CITY OF RYDE SUBMISSION ON DIRECTOR-GENERAL'S REQUIREMENTS FOR NORTH RYDE STATION PRECINCT (Station North & Station South Sites)

The Department of Planning and Infrastructure has requested Council's comments on draft Director General's Requirements (DGRs) for initial works to support implementation of certain lands within the North Ryde Station Urban Activation Precinct. The proposed works consist mainly of land administration (including subdivision), site preparation and infrastructure required to support future development on the land.

Station North and Station South Proposed Layout Plan

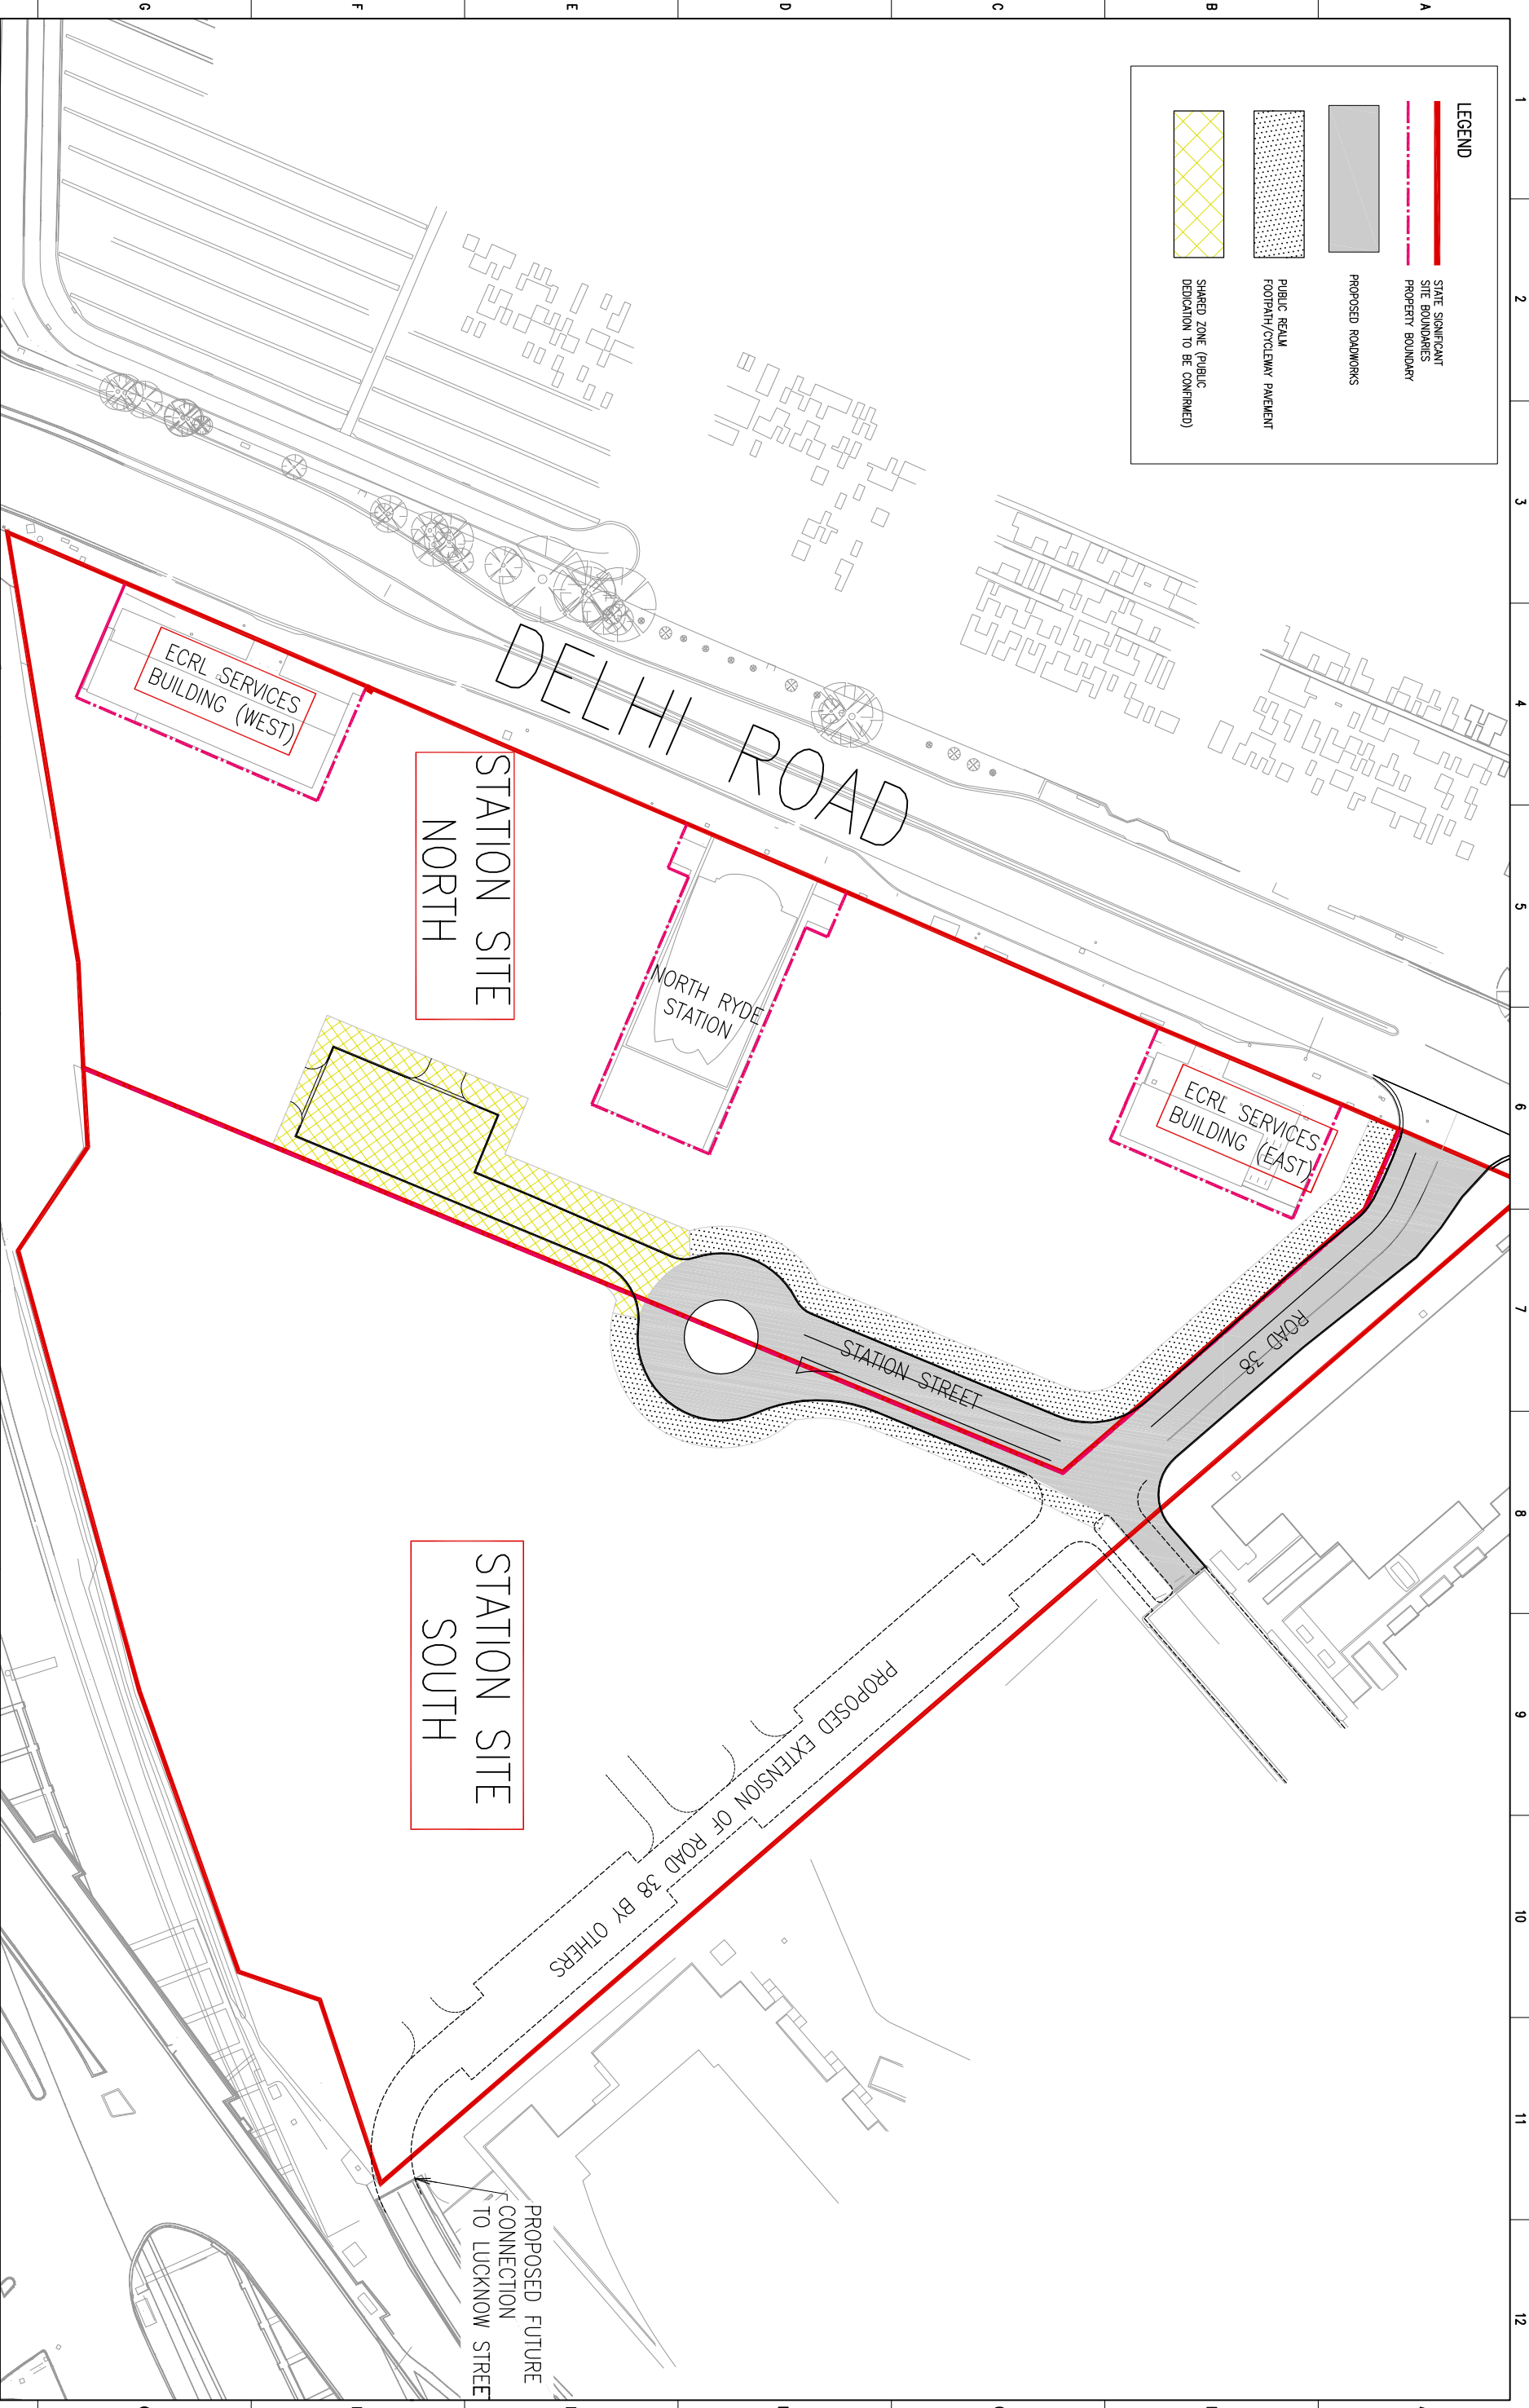
The provision of adequate infrastructure is an important first step in the physical redevelopment of the Station Precinct. This submission is accompanied by a plan that shows location of roads, a large turning circle, a shared public domain area and other elements. If the purpose of the application is simply to test if this plan is appropriate then Council has some concerns with the process. It would seem necessary that any plan for assessment should come as a result of the investigations that are outlined in the draft DGRs.

1. Is the illustrated road pattern the best option to connect the broader community to the railway station? Is there a need to explore a widening or adjustment of Delhi Road to provide bus bays so that express buses can pick up and set down without a lengthy and circuitous journey into the site?

2. Is there a need to consider a less truncated street pattern? Are there options for better connections in and out of the site, possibly an "Out only" slip lane type connection to Delhi Road (west of the station).

3. Does the road pattern provide the connections to support facilities especially schools and child care? Will the road pattern and any bus and train connections enable easy and safe access for students of all ages to schools? In particular, how will children get to primary school? Council has received many representations from the local school community raising concern at the lack of capacity available to cater for an expanded population in the area. In such circumstances, mobility to reach schools that are further afield may become especially important.

4. Does the proposed road and public domain pattern function without an effective bridge connection to the M2 precinct of the UAP? The suggestion that the proposed pedestrian bridge be constructed in stages is a major concern to Council as it will mean that the Station Precinct becomes more isolated from the facilities
